61 Mobbs Lane, Epping (Former Channel 7 Site)

**Modification to the car park layout for
Buildings 7 and 8 (MP 10_0158 MOD 6)**

Director-General's
Environmental Assessment Report
Section 75W of the
Environmental Planning and Assessment Act 1979

February 2013

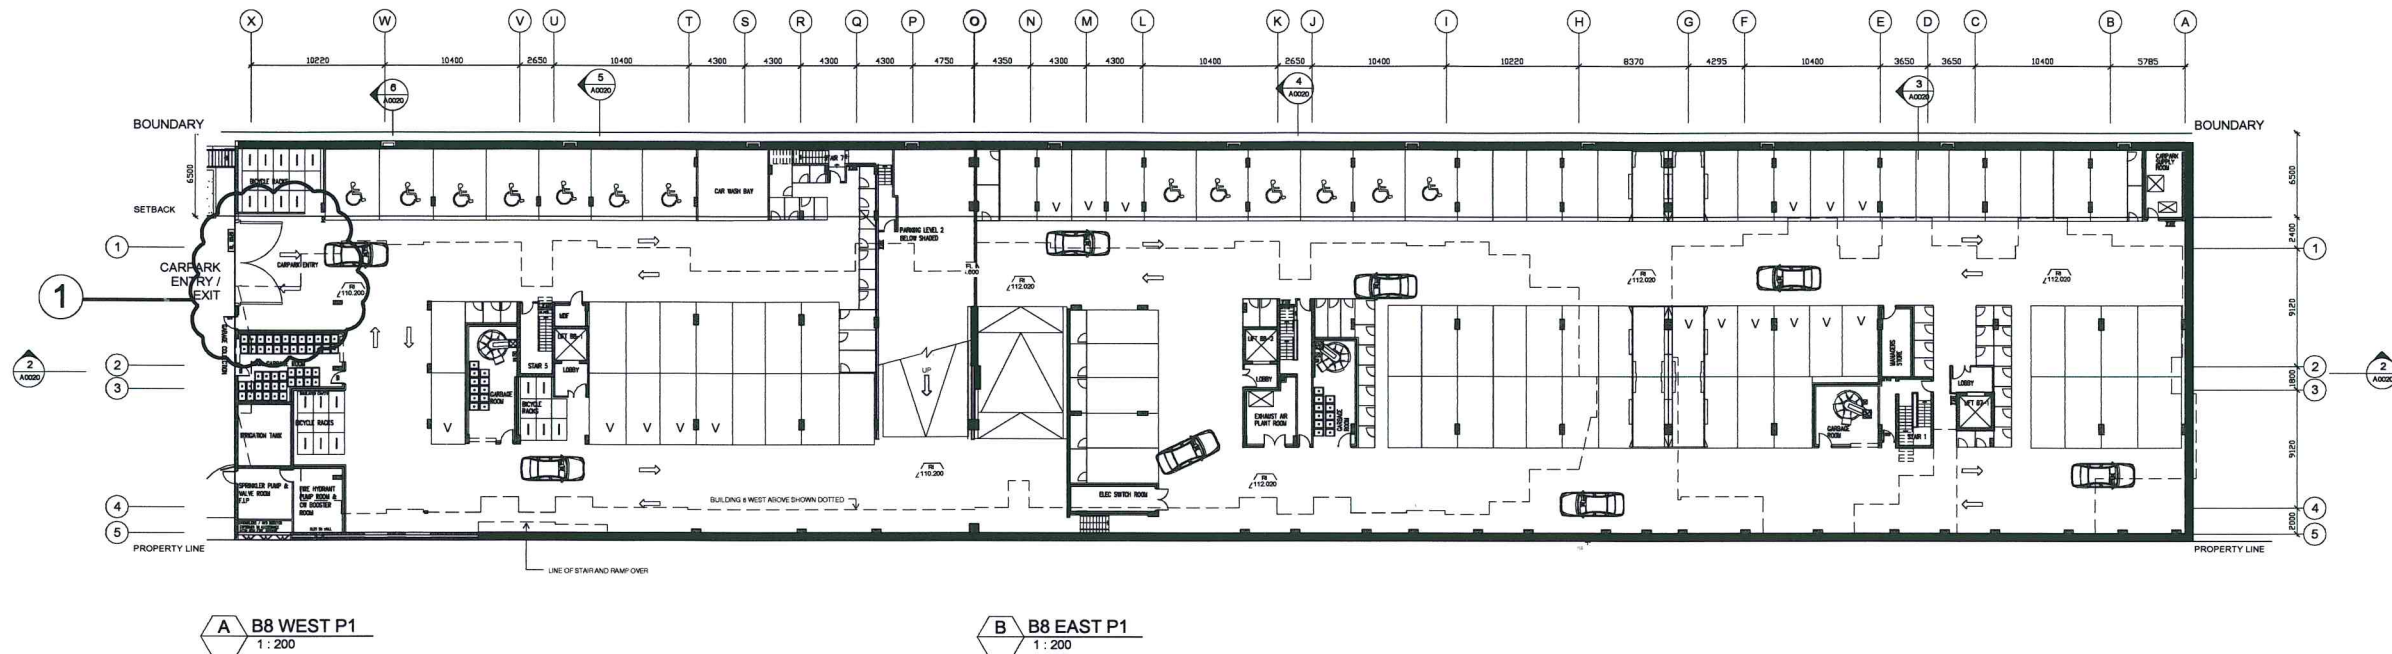
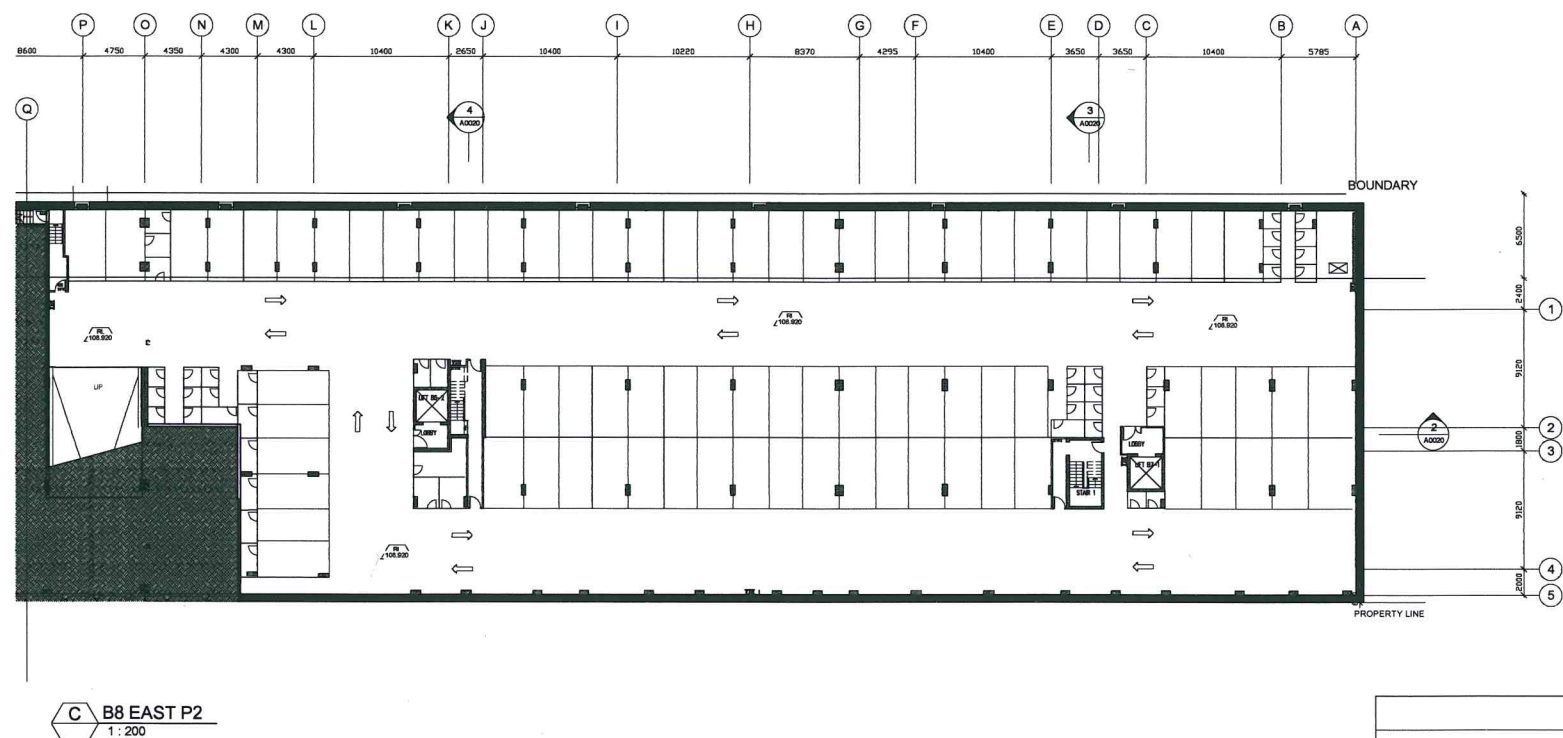
The approved plan indicates the car park entrance on the south of the western elevation for Building 8. As highlighted in section 2.1 **Figure 3**, the approved elevation of Building 8 shows the car park roller door to be located to the north of the western elevation for Building 8. The proposed entrance has been relocated to the north to allow for consistency with the approved elevation drawing.

The department considers the relocation of the car park entrance to the north to ensure consistency with the elevation drawing approved under MP10_0158 MOD 2 appropriate, and will not result in any adverse traffic impacts. In addition, the proposed car park entrance caters for the topography on site to improve construction. As a result of the proposed relocation of the car park entrance, minor internal reconfiguration of service rooms and bicycle storage spaces will be necessary. The department considers these changes are minor and will not reduce the functional aspect of the car park.

The department therefore, considers the proposed relocation of the car park entrance to the north of the western elevation acceptable.

It is therefore recommended that the amended car park plan A0011C be approved as outlined in the recommended Instrument of Modification Approval.

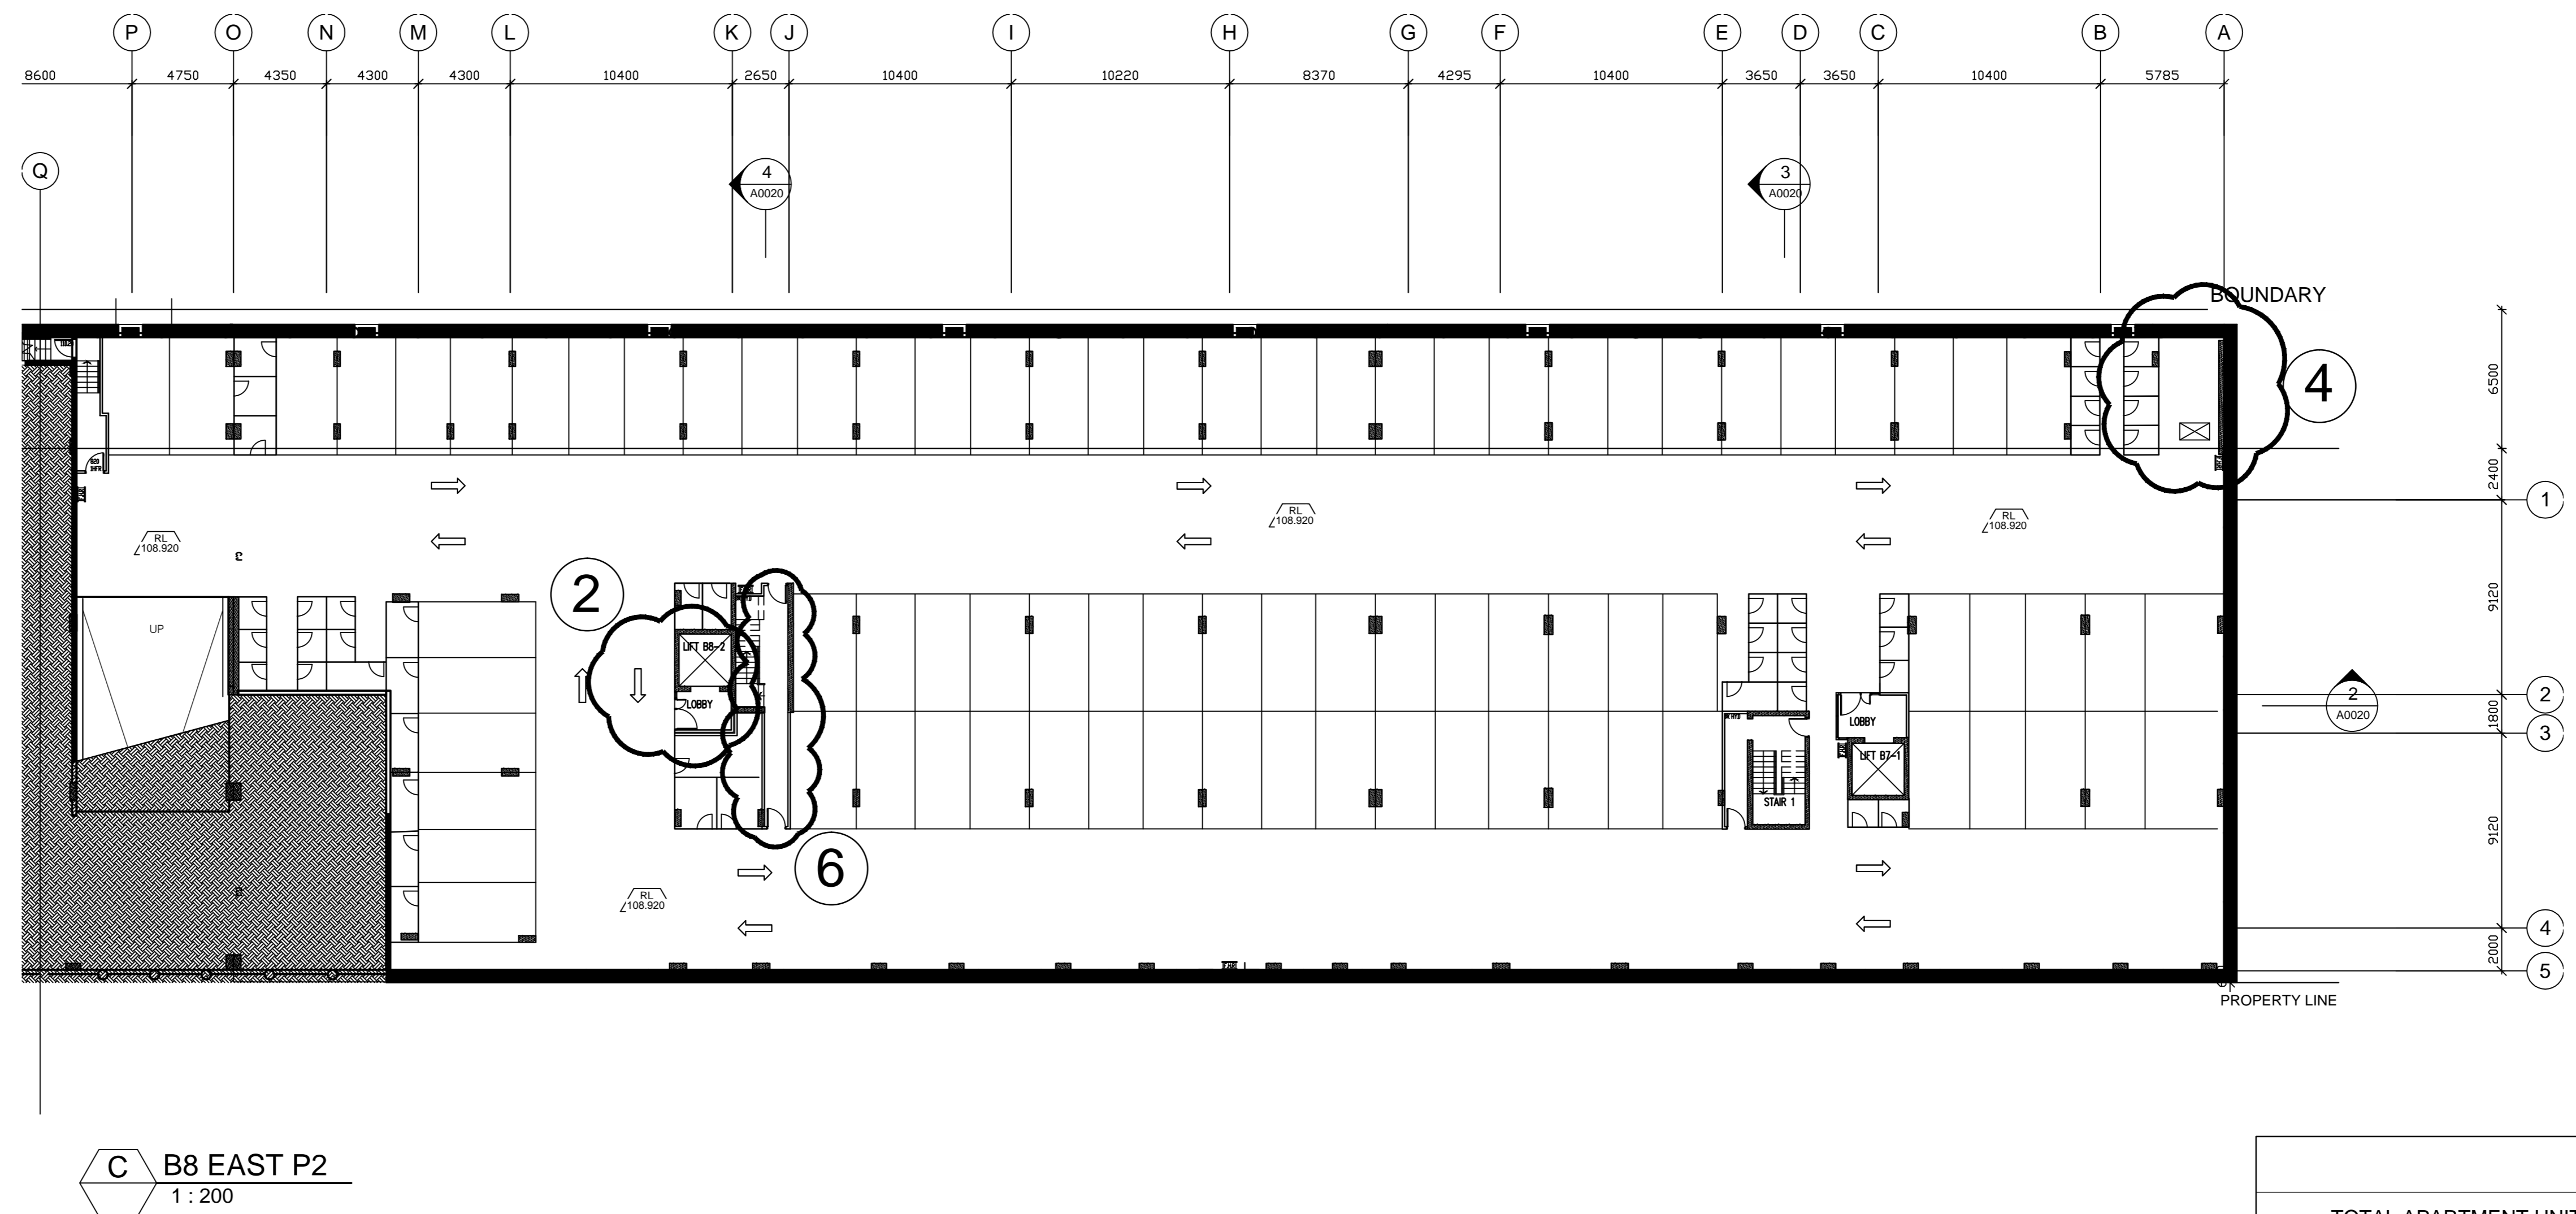
The first bullet point in Condition A10 requires strata plan sheet 4 of 23 to be amended to reflect the car park entrance to the south, as shown in the approved car park plans A0011A and A8101. The department notes that this bullet point will need to be deleted as the approved strata plan already depicts the car park entrance to the north, and therefore consistent with the proposed car park plan.
